Application No: FG/58/22/PL
Site Address: 4 The Pantiles Ferringham Lane Ferring BN12 5NE
Description of works: Conversion of the top two floors into a 1 No 3 bed flat (resubmission following FG/22/22/PL). This site is in CIL Zone 4 (Zero Rated) as other development.

Thank you for your internet representation made on 3rd May 2022 which has been recorded as an objection with the comments as follows:

Detailed site plan Not to Scale

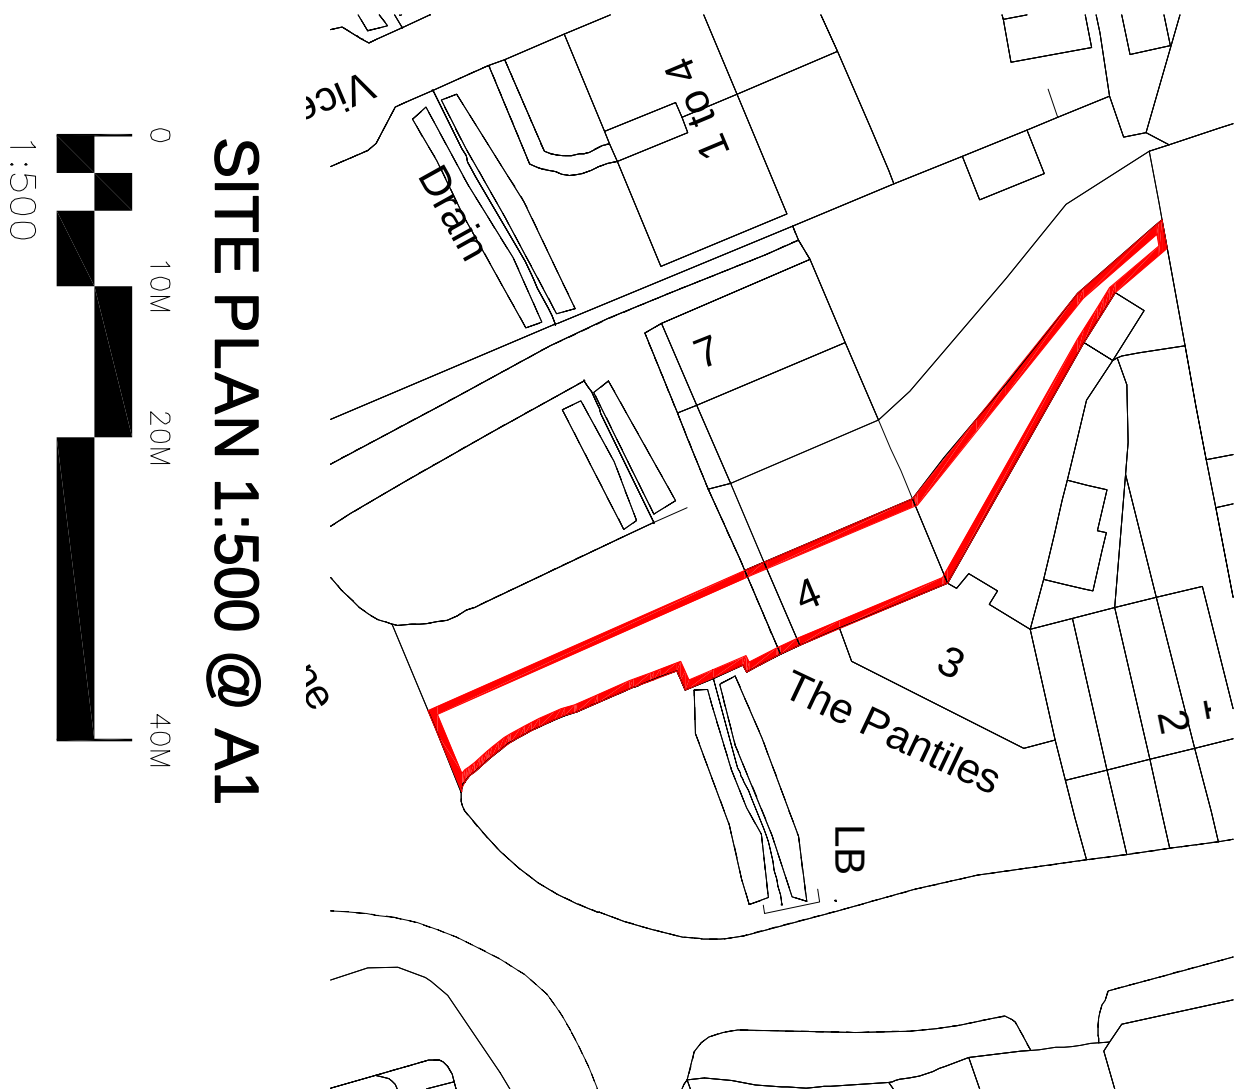
- The application does not define the Riparian Ownership responsibilities for the watercourse (shown on the plan) which crosses the site at the front of the property. It is not known whether that responsibility will rest entirely with the owner of the ground floor premises or be held jointly with the residential property on the first and second floors.
- There are no defined parking spaces and it is not clear whether any dedicated spaces are provided for the flat or how they would be allocated for the residents private use.
